The following provides comments against Northgate Farm PMA Options Technical Note, submitted as part of deadline 8a.

Section 1.1 Introduction

Figure 1 – DCO Application proposed PMA Route

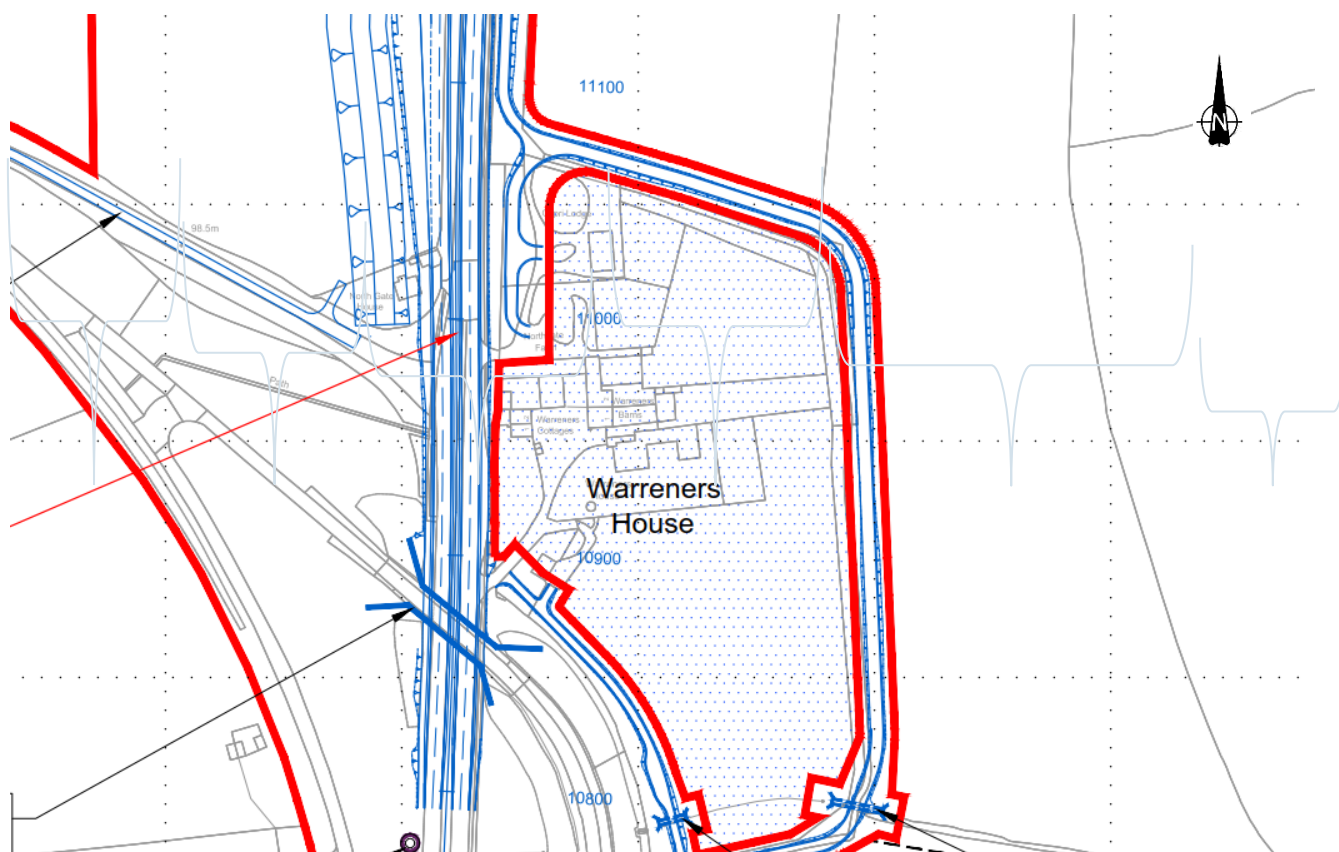
As previously documented in detail the current proposal is not a good solution and has a number of major issues, which we recognise cannot be resolved. This includes, but not limited to:

1. To facilitate access into Northgate Farm additional works are required to redesign the front of the property. This includes felling trees which will further open up views of the new Dual carriageway and access roads. Previously the Applicant had placed great store in the benefit of these same trees to screen Northgate Farm from the worse of the visual effect.
2. With the loss of privacy and additional constraints imposed by the access road we understand why this option is not good solution for Mr Davidson.
3. Given the strength of feeling from Mr Davidson and the current circumstances this option is not viable.

Figure 2 - Alternative Route A

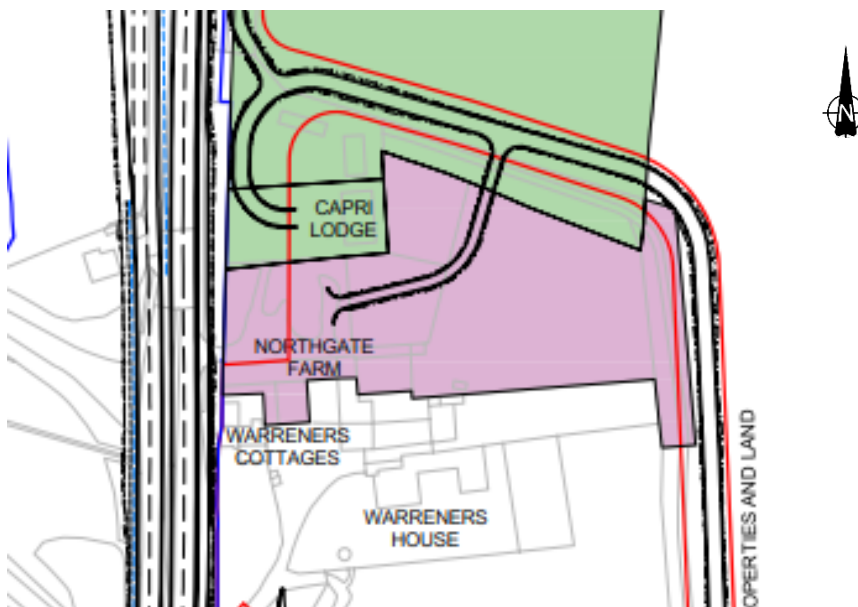
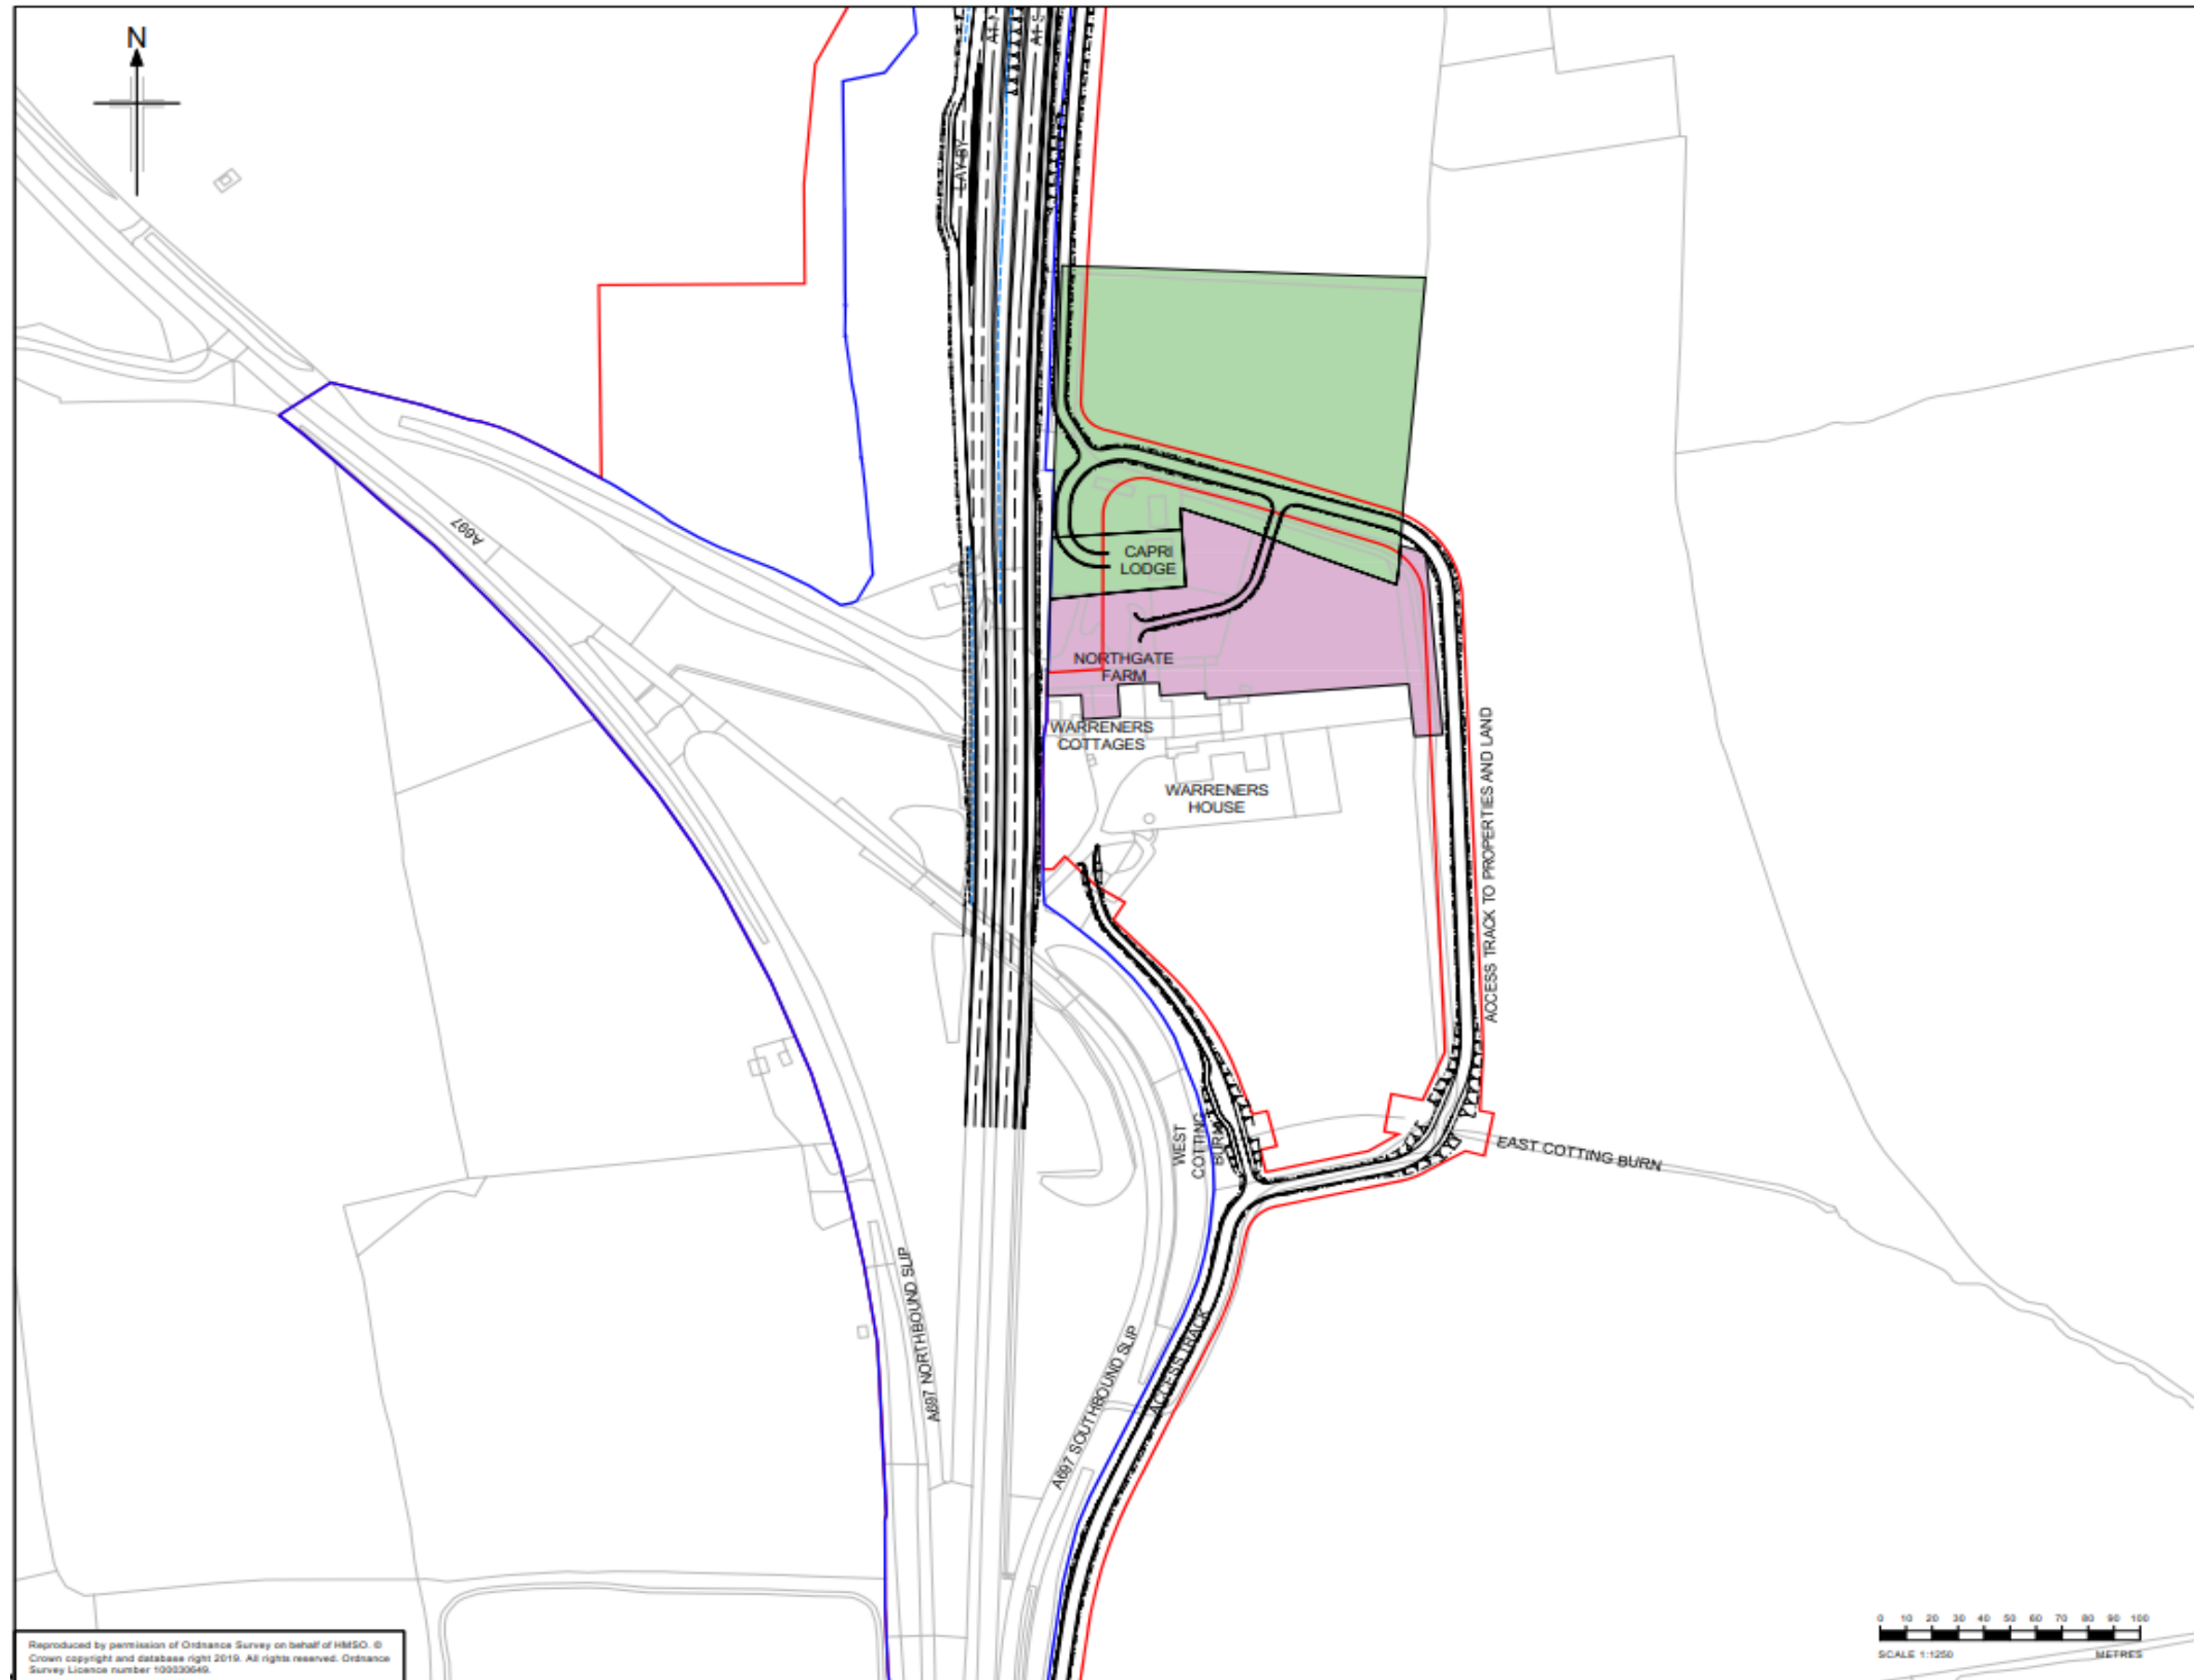
Section 1.1.2

Alternative Route A was first presented to the Applicant at a meeting on the 13th January 2021 and subsequently further detailed in an email on the 5th February 2021. Whilst it is recognised that there are some benefits for Northgate Farm in this option the overriding motivation in proposing the solution was to appease Mr Davidson and avoid accessing via the front of his property. In making this proposal this entailed a number of compromises which included:

1. Take on the responsibility for constructing a 75-metre tarmac road which would partition the property.
2. With the road running through the centre of the garden we were making a compromise on visual effect and air quality.
3. Accept the loss of additional trees at the front of the property.
4. Take on additional responsibility for land works and landscaping. This included the repositioning of a well-established vegetable garden.

Although it is understood that this option is not favoured by Mr Davidson, as it involves some shared access, it is significantly better than the current proposal. Furthermore, it should be recognised that all three routes require a degree of shared use and maintenance.

Figure 3 – Alternative Route B

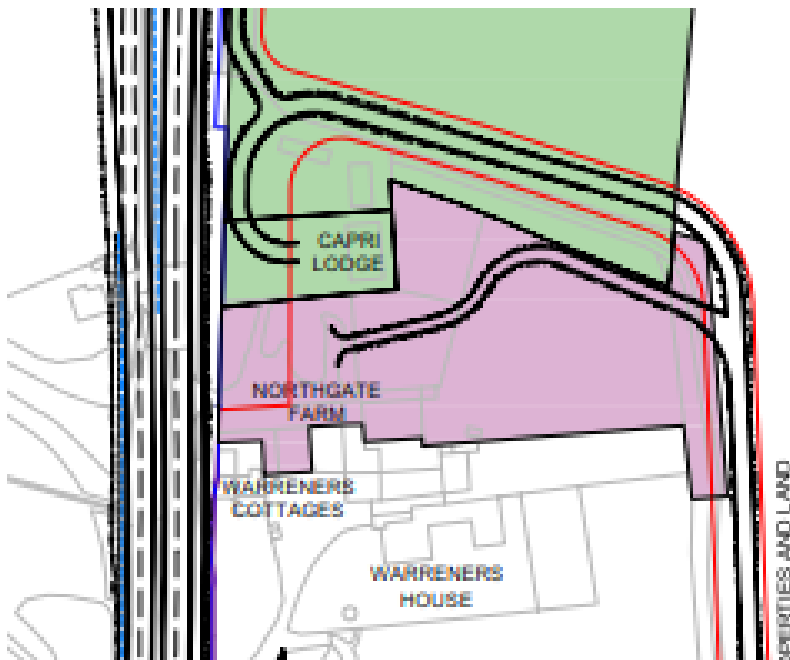
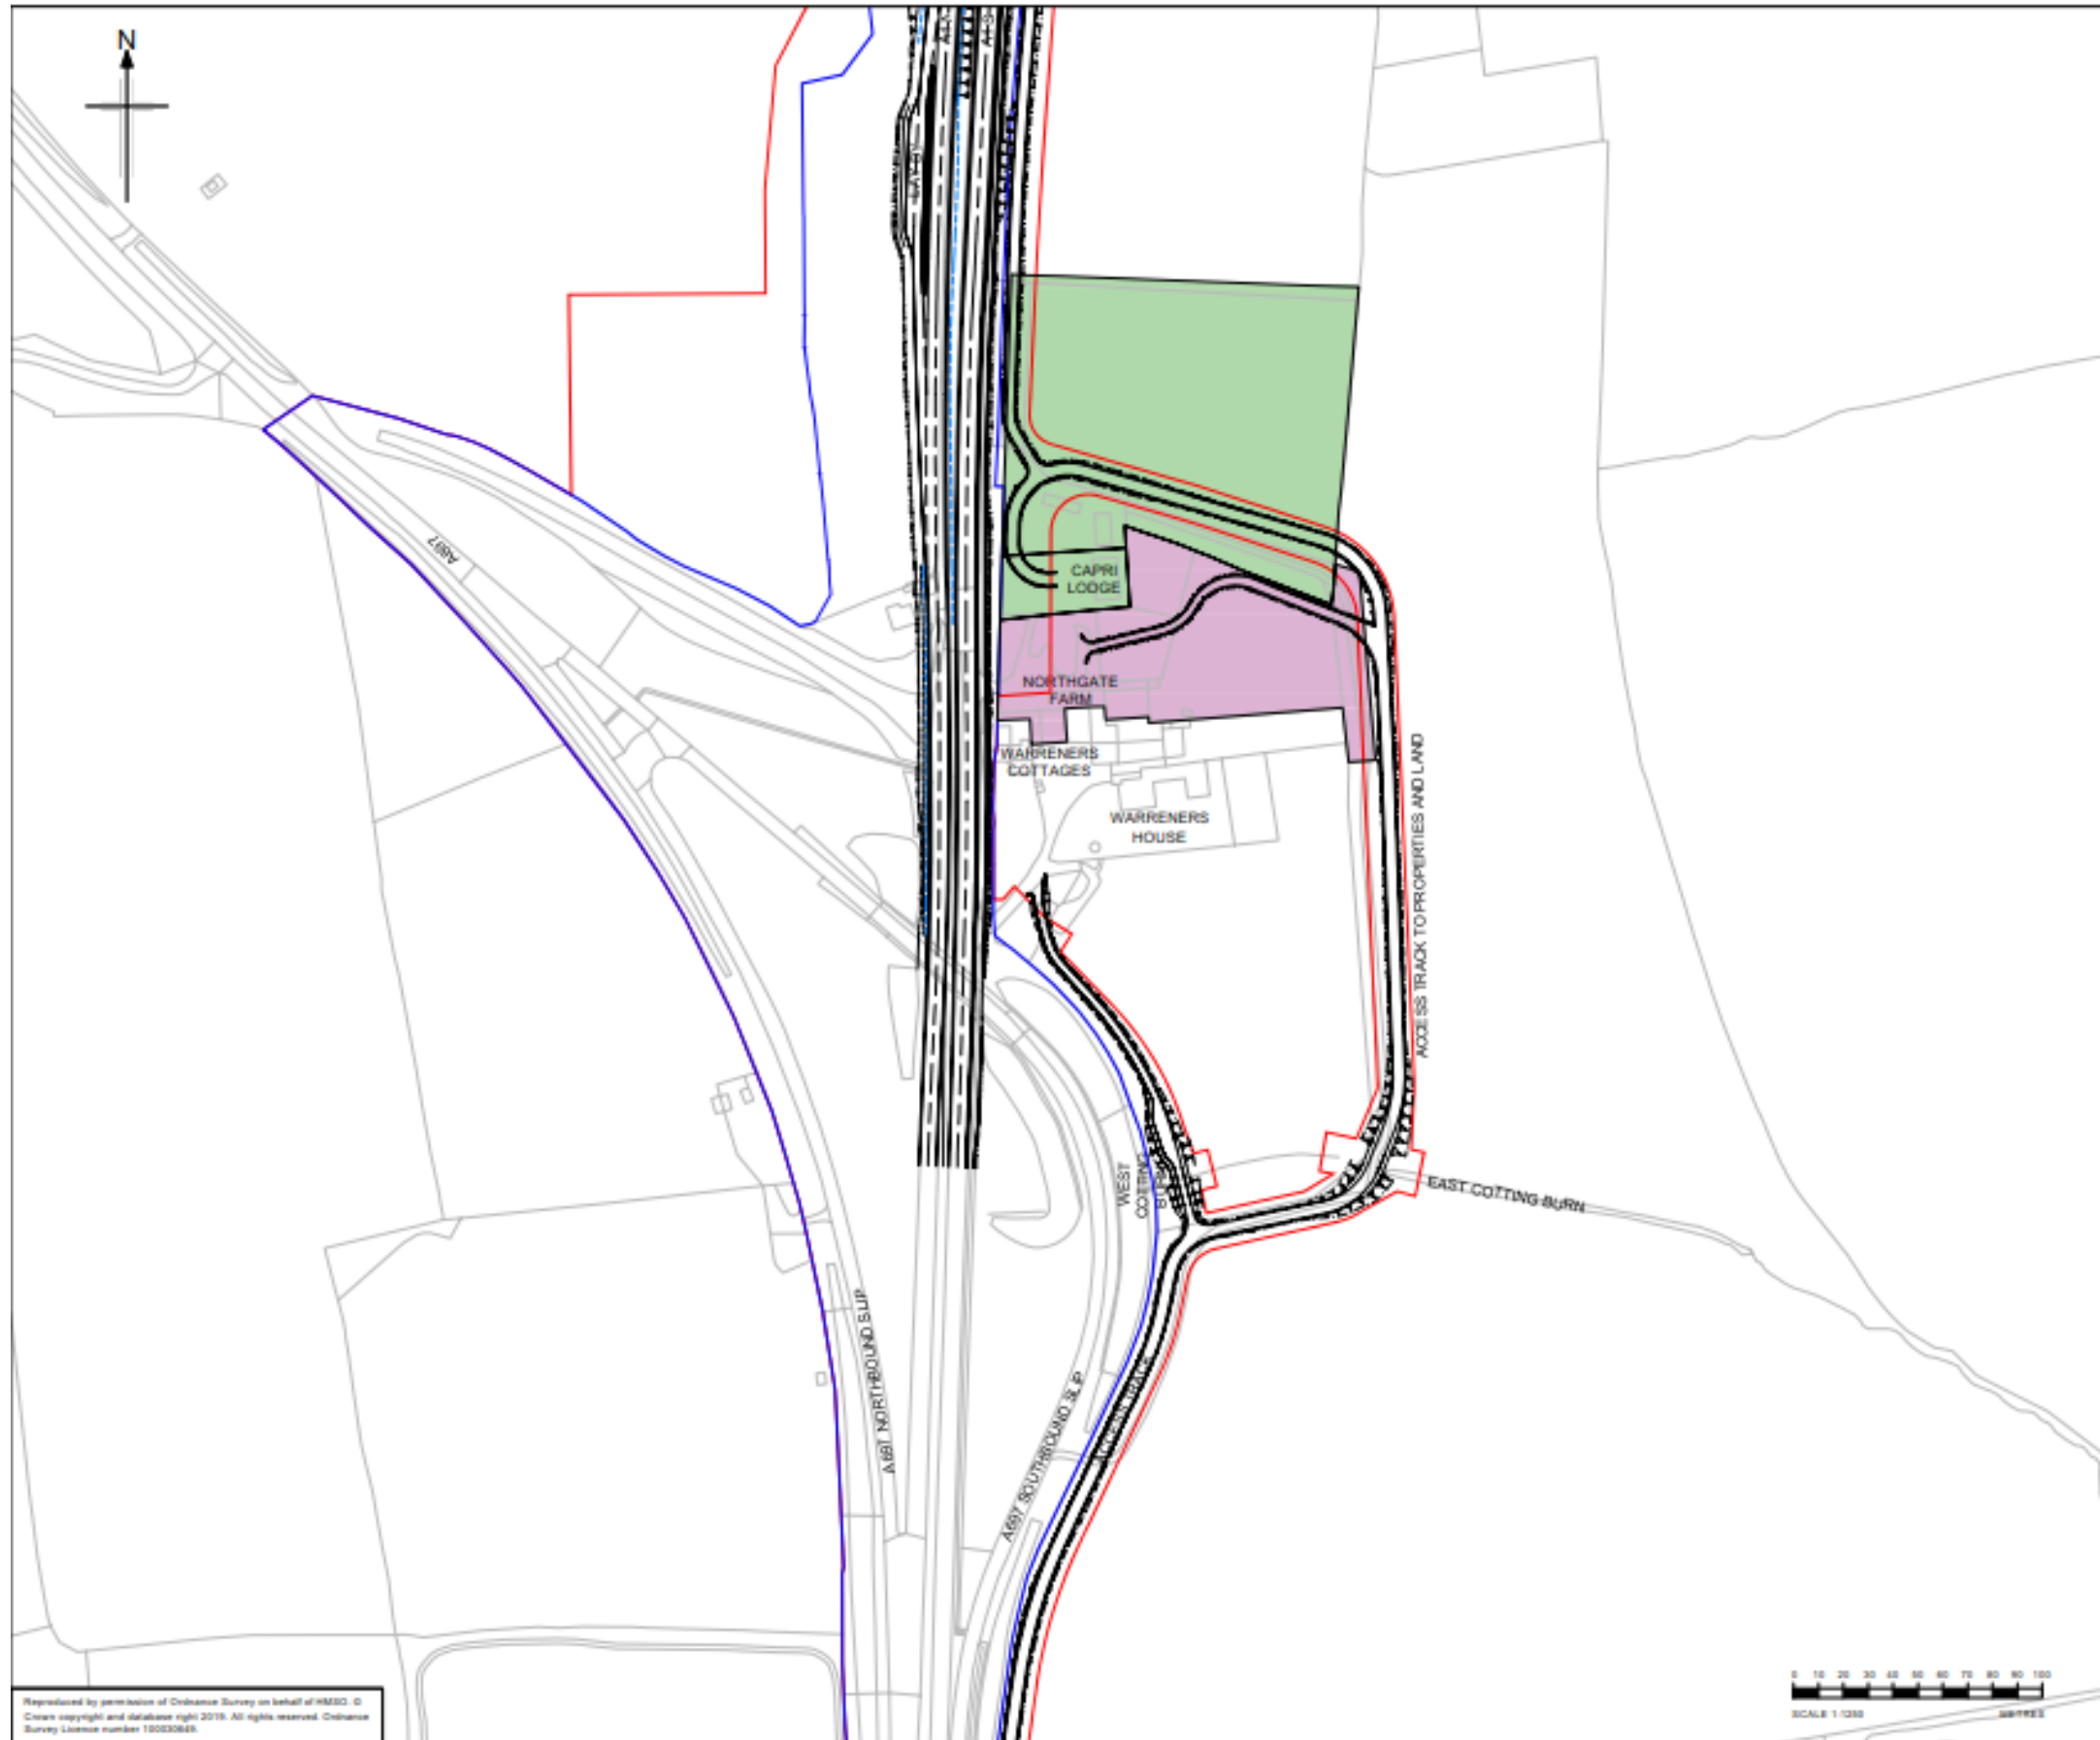
Section 1.2.2

The Applicant is correct in highlighting that Alternative Route B does not require agreement between the parties but does not recognise that it would require a major compromise, from Northgate Farm to resolve a problem that was not of its making. Although we were prepared to make compromises for Alternative A this option represents a much larger scale of concession, particularly with the impact upon the woodland. This includes the following:

1. The additional access road would mean that we have two access roads running through our property within the woodland. The additional access road would significantly exasperate all the issues previously raised in respect to the woodland. This includes:
 - a. Privacy
 - b. Wildlife
 - c. Outlook
 - d. Air Quality
 - e. Noise
 - f. Loss of trees

- g. Safety and security
 - h. Environmental impact
2. The construction of the additional tarmac road, stretching the length of Northgate Farm property (estimated at 135 metres), significantly adds to the amount of tarmac on view

3. The construction of such a road would represent a major undertaking for us.
 4. The road through Northgate would take up a significant percentage of the property imposing constraints on how the property could be used in the future.

5. The road would partition the property leaving areas of dead space which would not be utilised.
 6. The road creates additional burden and responsibility on the property for maintenance.

7. The road would require a significant amount of additional land works and landscaping. This would include managing septic tank and water pipes which fall within the route of the road. The well-established vegetable garden would also need to be re-positioned.

It is estimated that the new road will be approximately 135 metres in length. While I understand that this is negligible when considering the rest of the scheme, it represents a major loss of garden to ourselves.

As previously discussed in the issue specific hearings we understand that the visual receptor sitting outside of the property (on the A1 verge) will not register the additional 135 metre access road, but nonetheless, will have a major visual effect which impacts the use of the garden. This further highlights the limitations of having a single visual receptor which sits outside the property.

The access road will introduce vehicle fumes and noise further into the centre of the garden. As Northgate Farm would be responsible for constructing the road, I am not sure how the proposed mitigation measures are relevant here.
